December 12, 2024

**Re: Quivira Estates at Quivira Dr NW (Lots 1-23)
Erosion and Sediment Control Plan
CPESC Stamp Date 12/9/2024 (D09E006)**

Principal Engineer, Planning Dept.
Development and Review Services

## TEMPORARY SEDIMENT AND EROSION CONTROL DRAWINGS

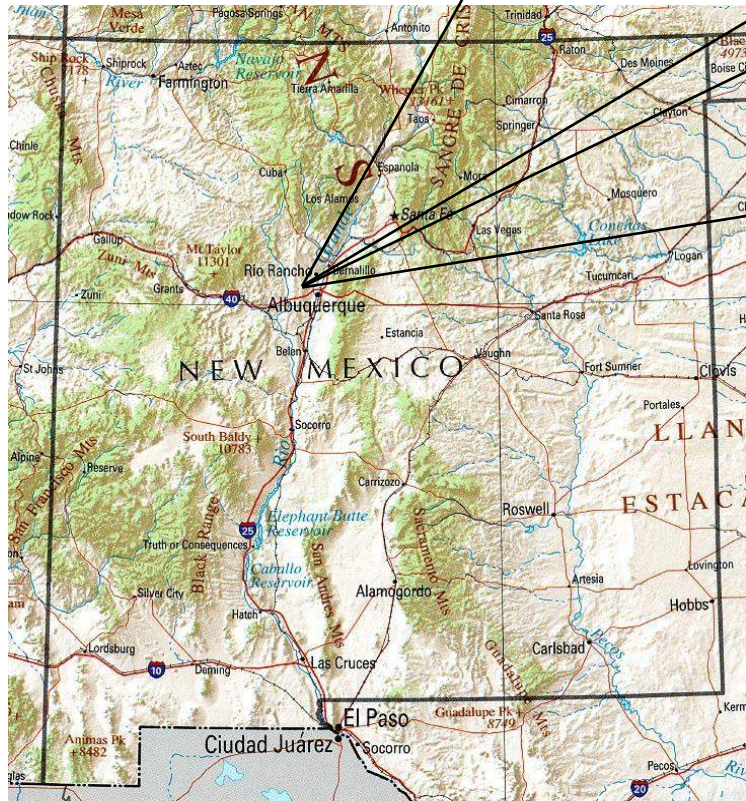
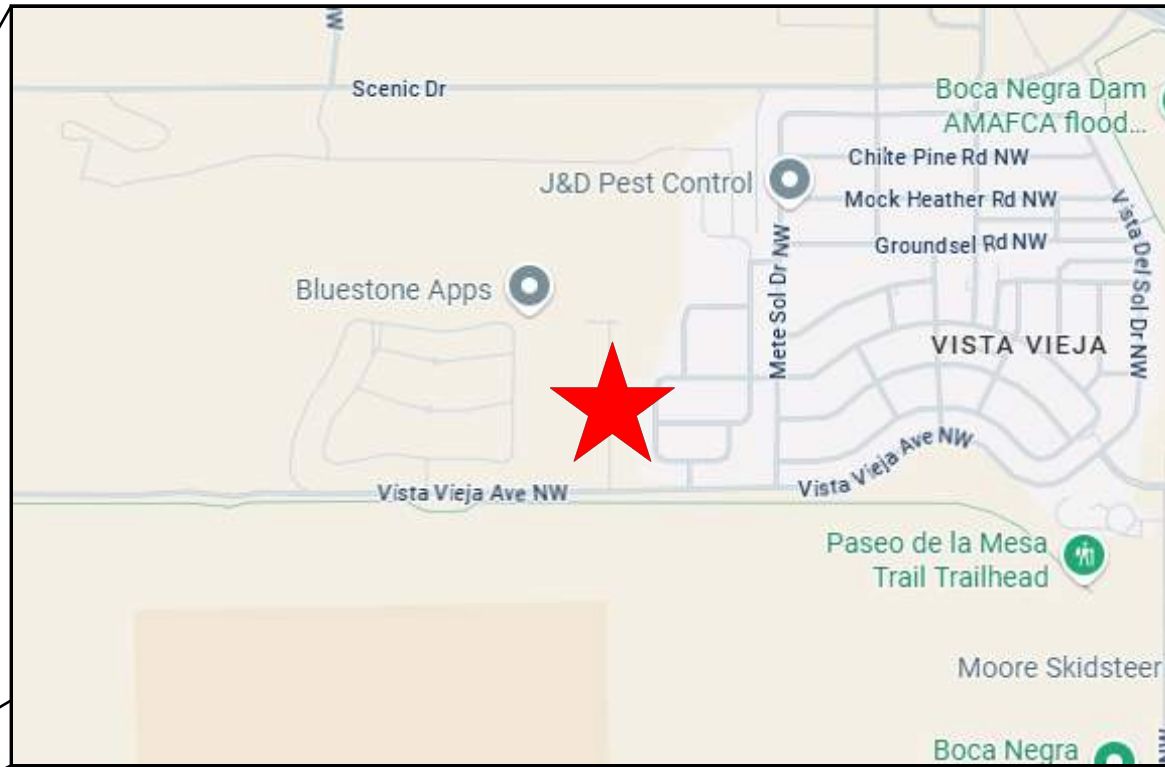
Based on the information in your submittal, received on 12/9/24 and 12/10/24, the above-referenced ESC Plan is approved for inclusion in the SWPPP with the condition that J-hooked silt-fence be added across the cutback curb swale on the south side of every lot where the street slope exceeds 2.5% (Lots 7-10 & 14-17). The EPA Notice of Intent (NOI) documentation has been reviewed and signed by the city and is attached, so the Erosion and Sediment Control Permit is approved for Building Permit.
